## PLANNING CONSULTATION RESPONSE

<b>Application No</b>	2025/0744
<b>Proposal</b>	Erection of 5 dwellings (2 pairs of semi-detached houses and 1 detached bungalow)
<b>Address</b>	Land at Windmill Avenue, Grimethorpe, Barnsley, S72 7AQ
<b>Date of Consultation Reply</b>	27/11/25
<b>Consultee</b>	Highways DC

Drawing Title  
**BLOCK PLAN OF SITE**

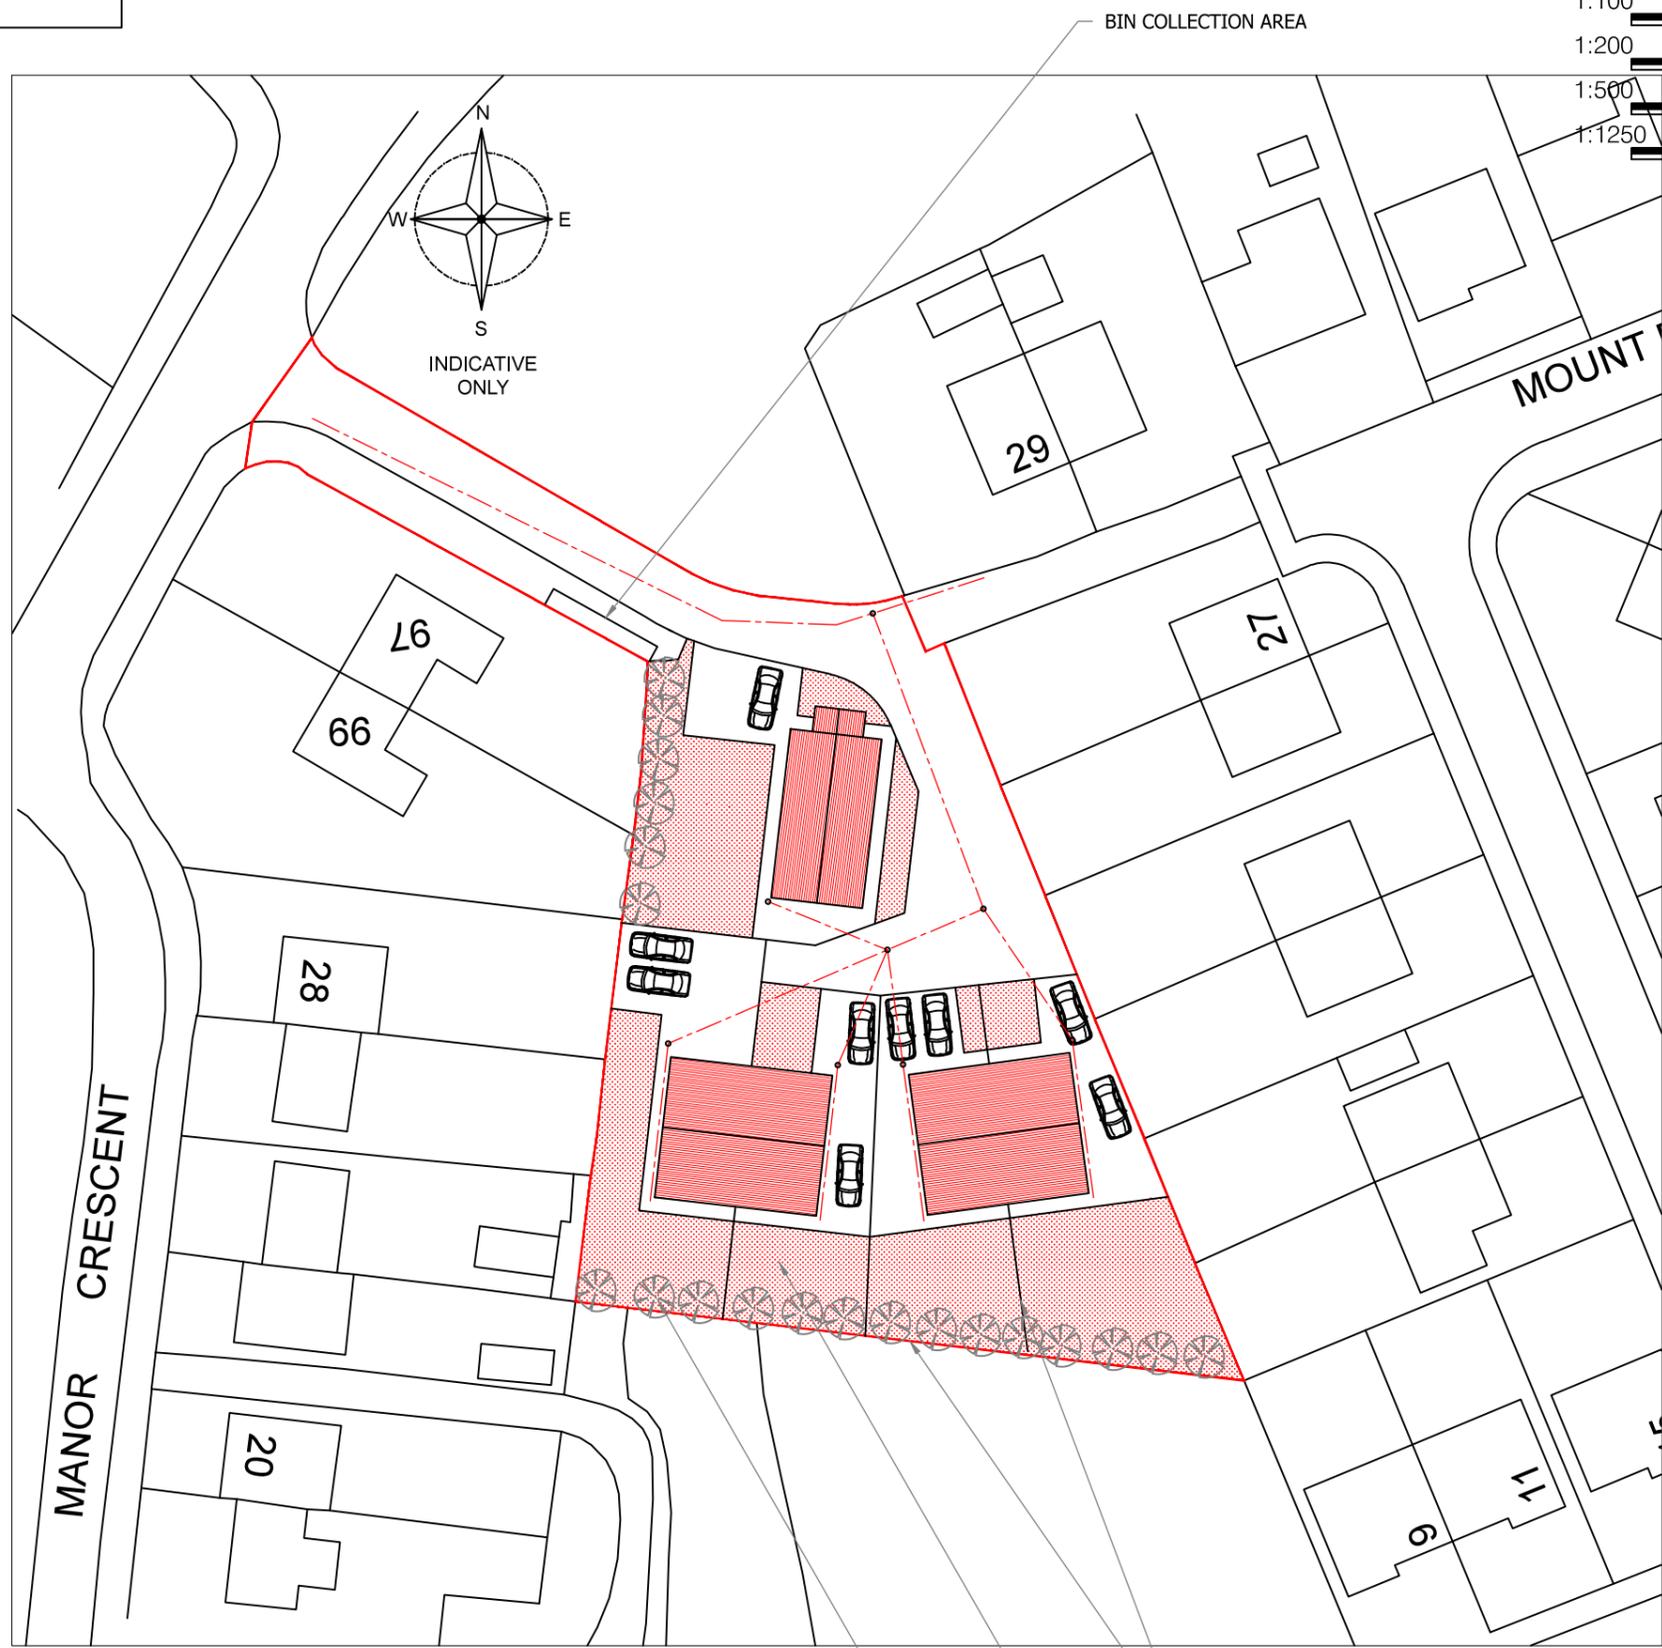
HDC officers would still raise concerns about vehicular and pedestrian access into the site. At present the footway measures at 2.6m wide with the carriageway only 4.2m in width. Considering the advice in the South Yorkshire Residential Design Guide and Manual for Streets, the access is presently too narrow to serve more than one vehicle; a minimum of 4.5m is required. The carriageway width could be increased by reducing the width of the footway which is well above the prescribed minimum of 2.0m.

An additional concern is the narrowing of the footway caused by the proposed bin store. The lowered kerb allowing transition from footway to shared space is shown after the store meaning the available width would be less than the 2.0m minimum described above. If the kerb lowering could be brought forward so the transition takes place prior to the bin store, the problem would be resolved.

A minimum unimpeded clearance of 6.0m is required to the rear of driveways and other parking spaces and three of the plots do not conform to this standard. This should be resolved before HDC officers give further comment.
